Yatton Keynell Parish Council Responses to Relevant Representations. (RR4941)

Title:
Figure 8-4: Agricultural Land Classification

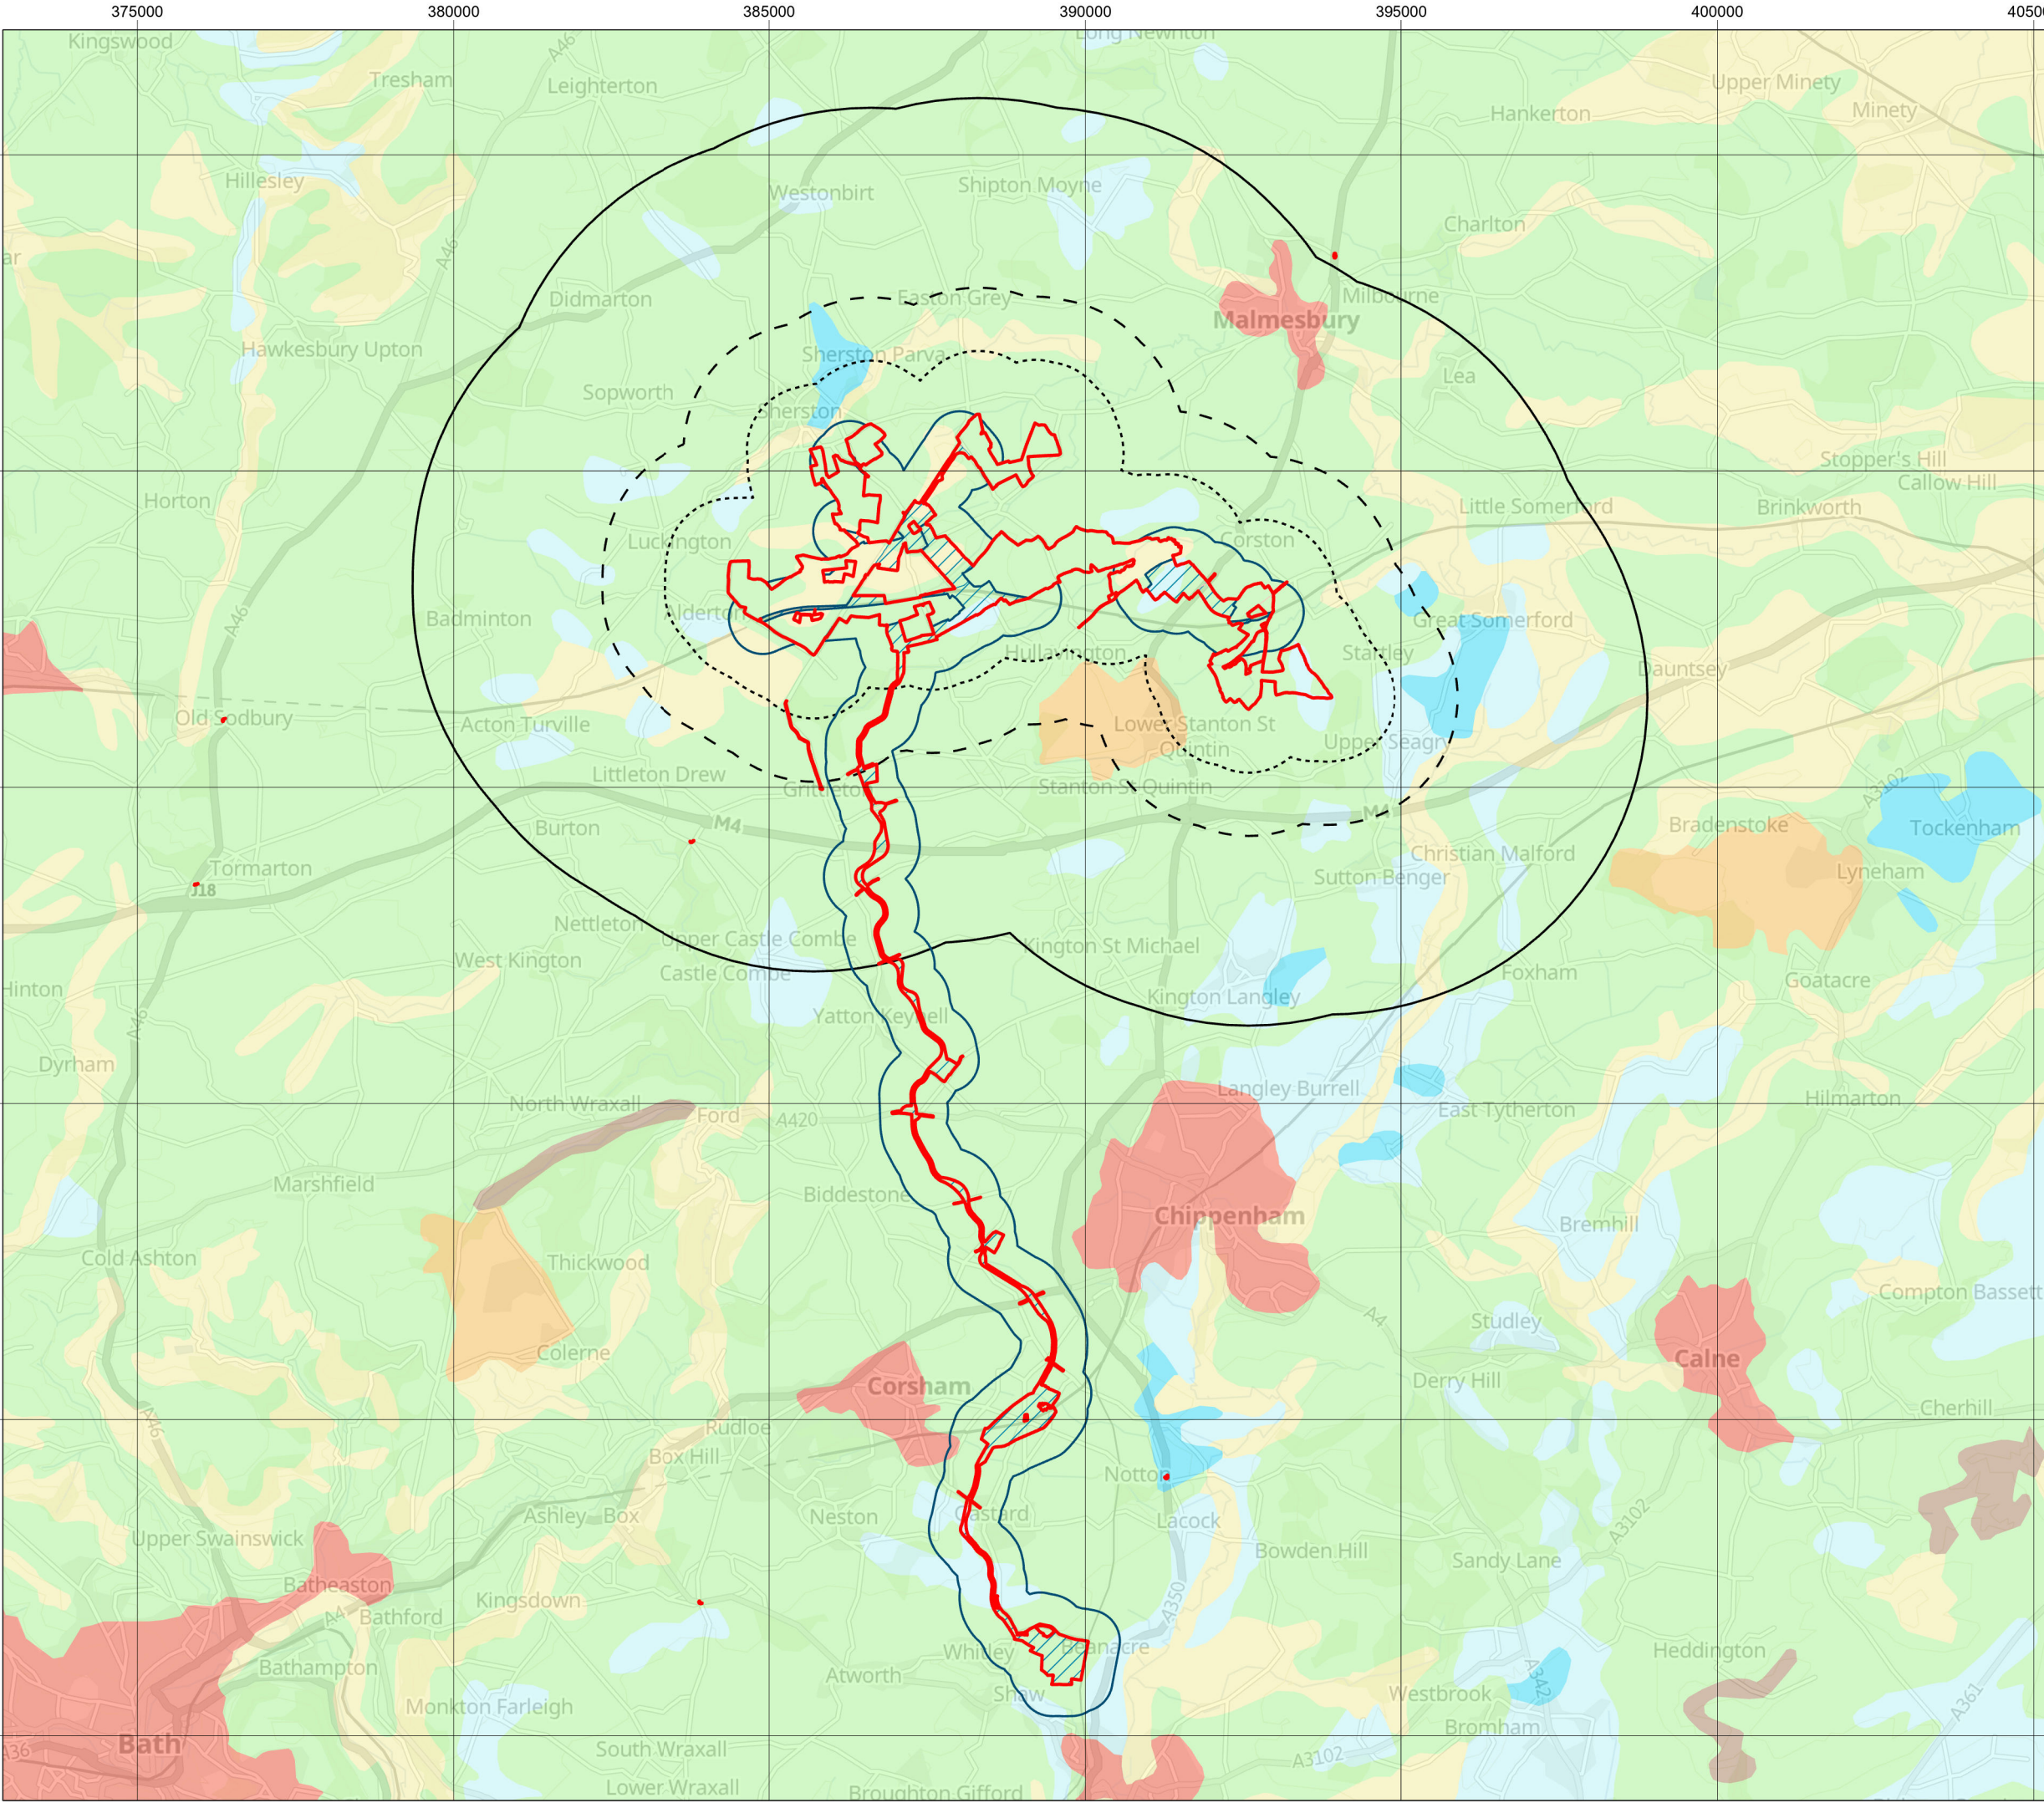
The Agricultural Lad Classification (ALC) should be based on historic data from recent arable rotation not a desk top exercise based on historic maps. The impact of sourcing arable crops lost from elsewhere should be taken into account assessing the projects impact.

How much land will be permanently lost from arable production given the statement - *as far as practicable*.

The assessment confirms that land would be taken out of arable rotation during the operational period of the Scheme but would remain productive and would be reinstated and returned to agricultural use as far as practicable following decommissioning.

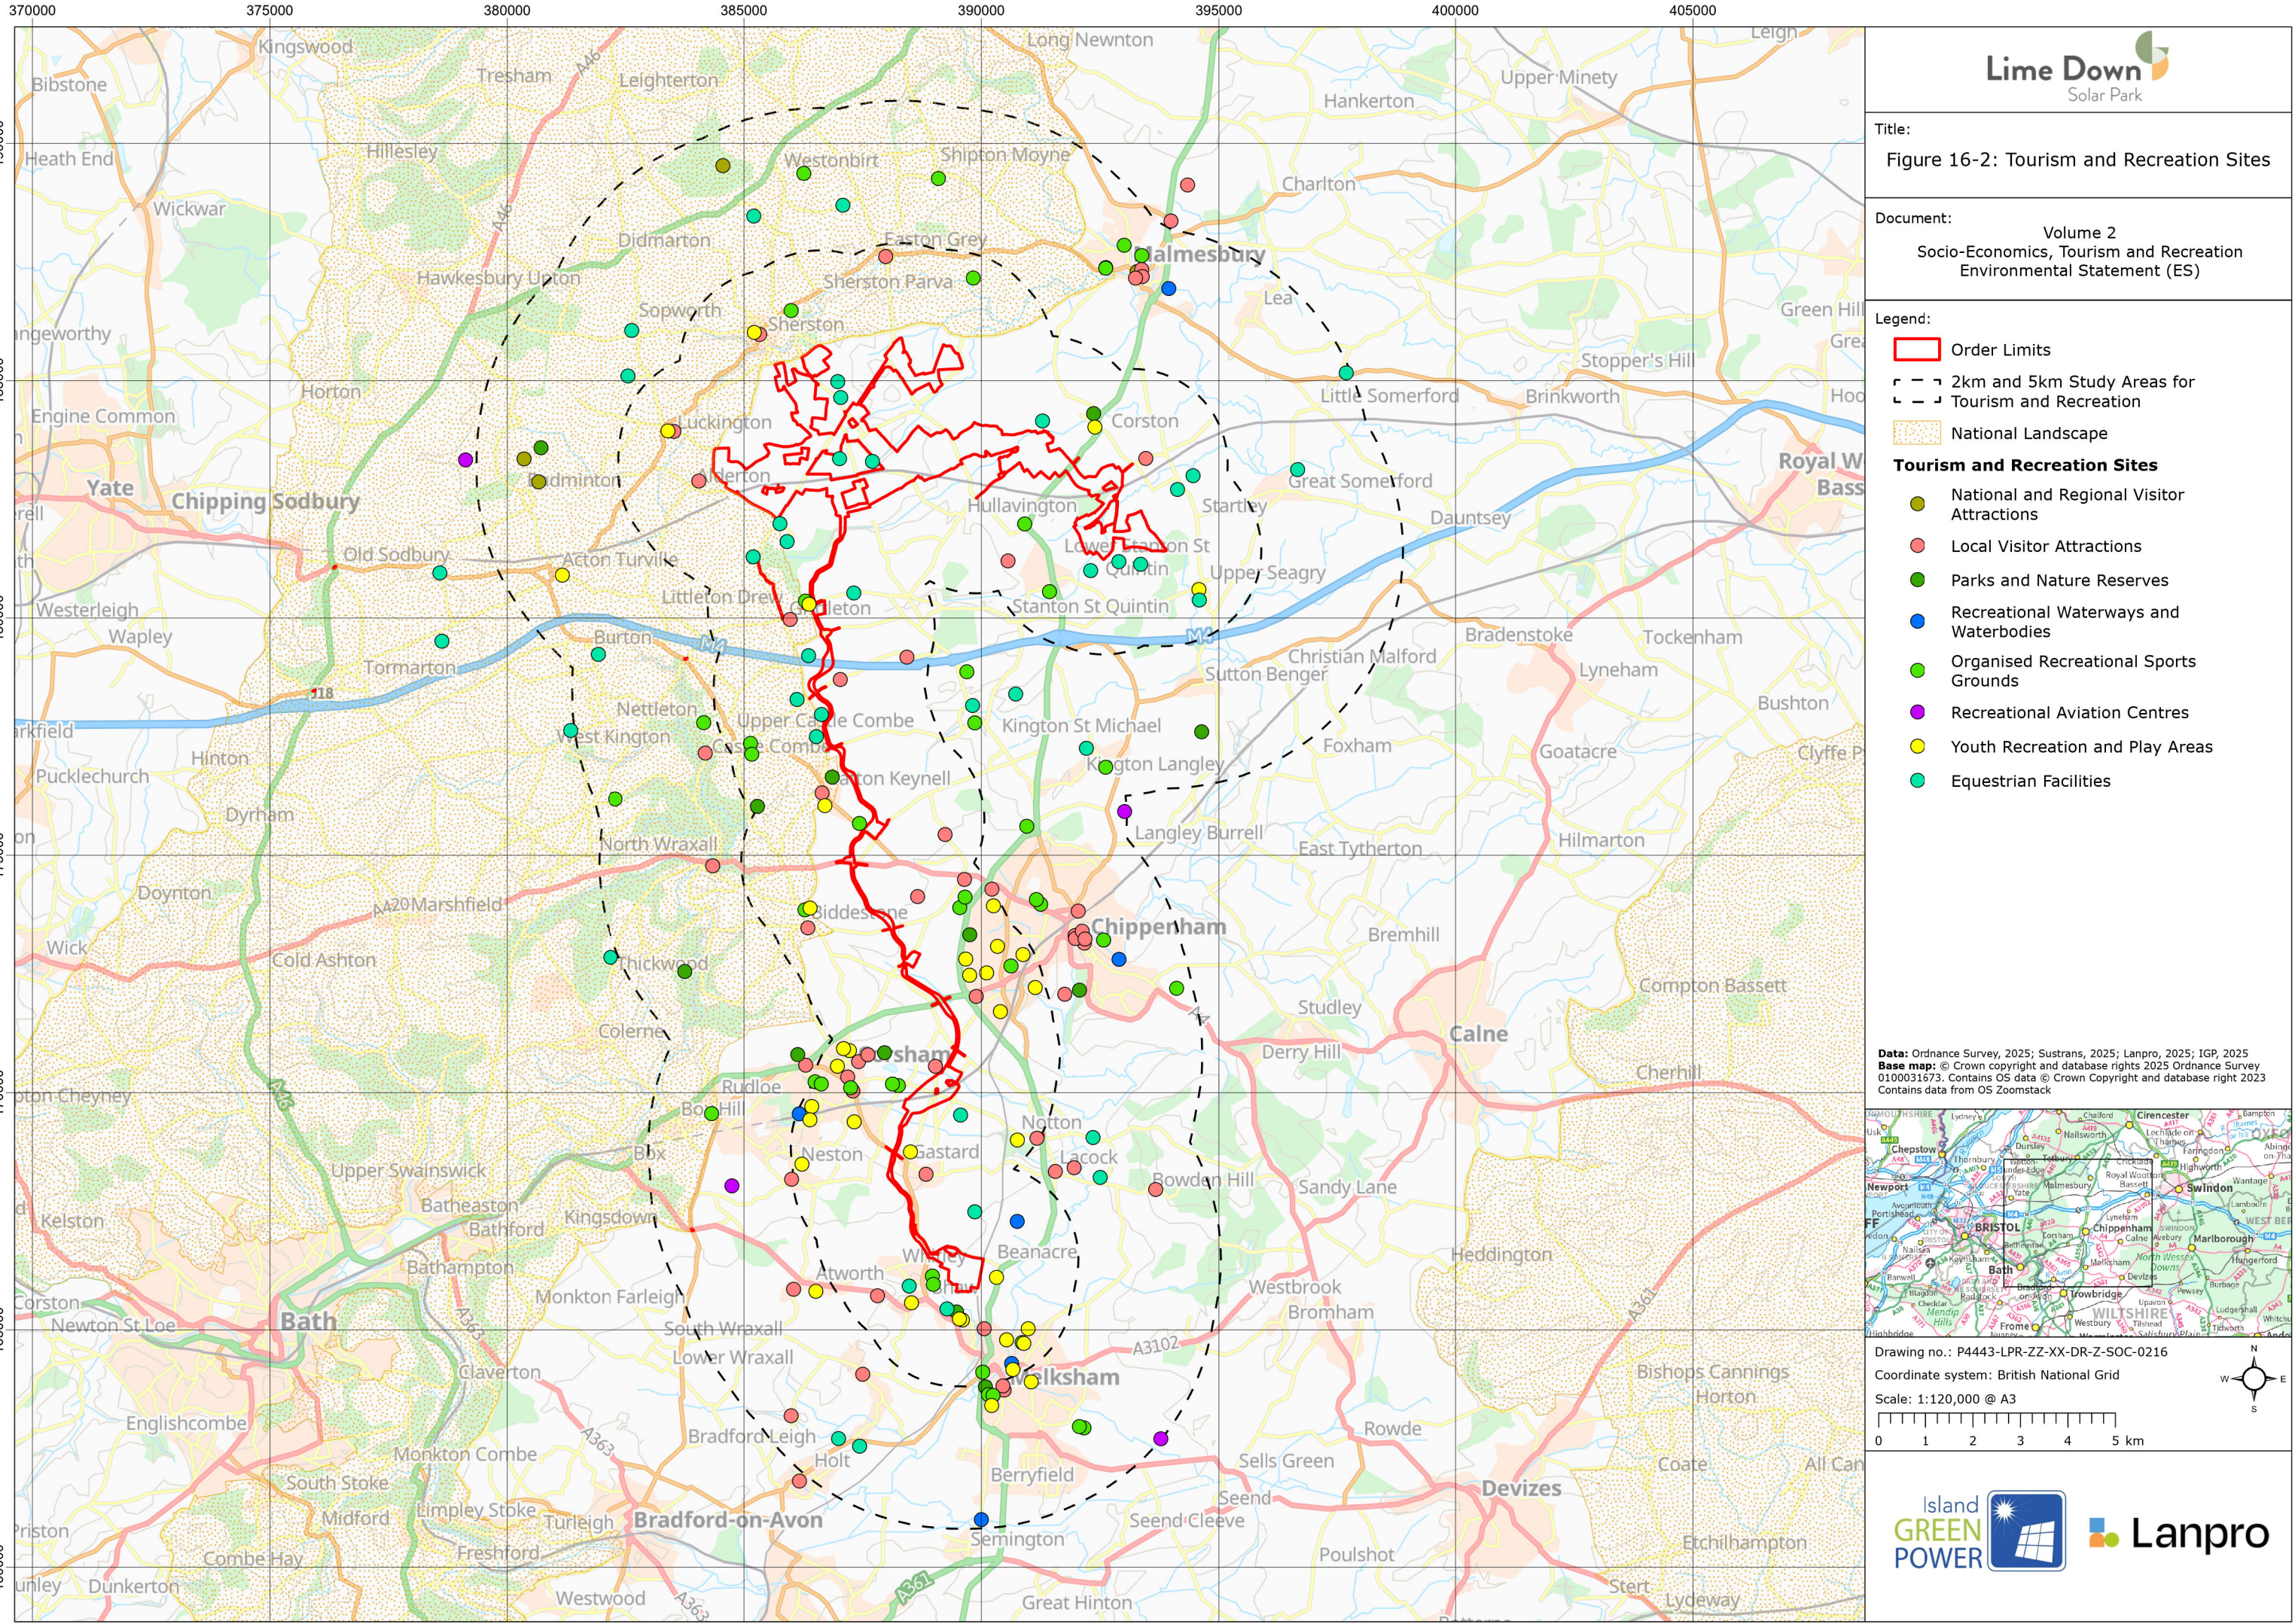
YKPC – 004 - Cumulative impact of solar farms in North Wiltshire - South Gloucestershire
Damage caused to local economy as a result of reduced tourism.

The response provided is inconsistent with a similar representation made by Grittleton Parish Council. Further work is required to show what the effects are on employment within the tourism sector in North Wiltshire.

Response to YKPC – 004 – *“Whilst the Scheme is anticipated to lead to some employment and economic losses to the tourism industry, these are not identified as significant adverse effects to the assessed 20 km economic Study Area”*

The Applicant has assessed that there is a likely worst-case temporary loss of 50 FTE tourism industry jobs as a result of the Scheme, as set out in ES Volume 1, Chapter 16: Socio Economics, Tourism and Recreation [APP-068]. This accounts for less than 0.7% of tourism-based employment within 5 km of the Scheme (BRES, 2023 data), and approximately 0.17% of tourism employment across Wiltshire (29,000 estimate from Visit Wiltshire, 2021). Where losses to tourism have been identified, these are worst-case estimates based on likely significant effects from the Scheme and do not include for additional mitigation measures being applied. This is also a temporary effect, anticipated to occur during construction, with recovery to tourism businesses anticipated to begin as soon as construction works are complete. During the Scheme's operational phase, the reduction in tourism compared to current conditions is anticipated to be equivalent to a loss of 11 FTE tourism-dependent jobs.
